## **Development Facilitation Team (DFT) – Review Comments**

**Project No: PR-2022-007063      Date: 02/7/2024      Agenda Item: #3 Zone Atlas Page: C-08, C-09**

**Legal Description: Lots 4 & 5, The Trails Unit 3A**

### **Application For: PS-2024-00022 – PRELIMINARY/FINAL PLAT**

Sheet 2 of 7
220437B

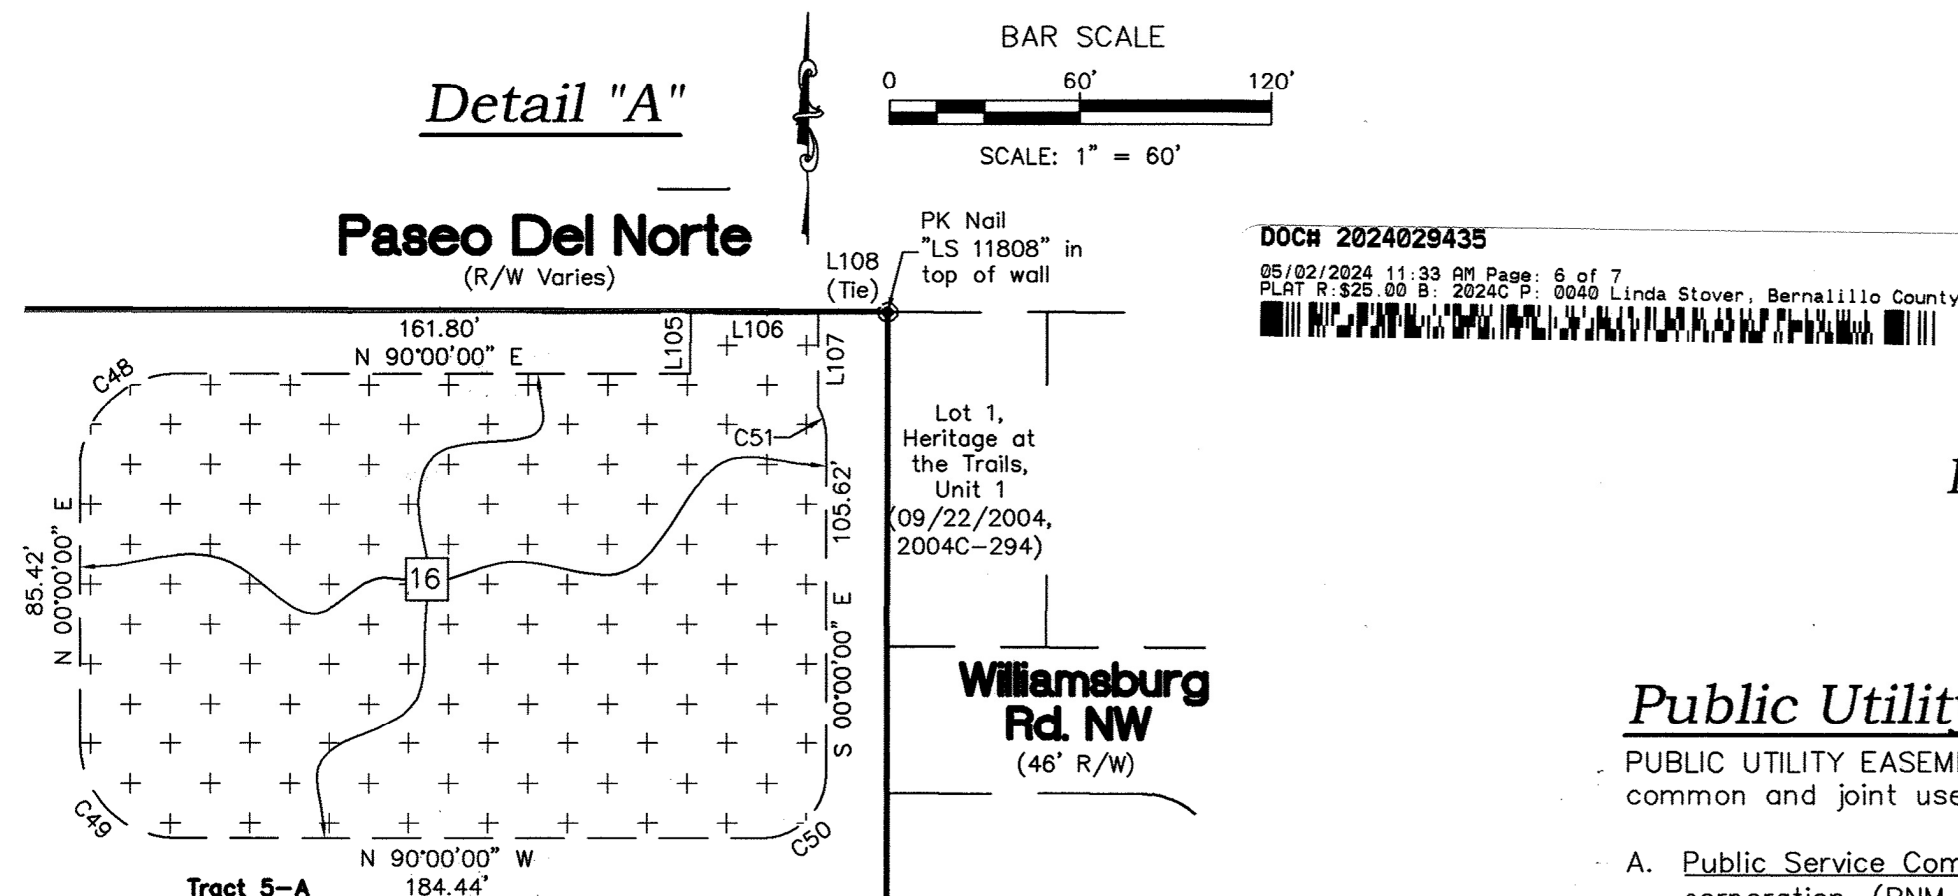
1. Please provide easement widths in the keyed notes section.
2. Easement #14 appears outside of the easement on the combined exhibit but on the exhibit that shows them separately, it seems to be overlapping where the waterline easement would be. Please confirm.
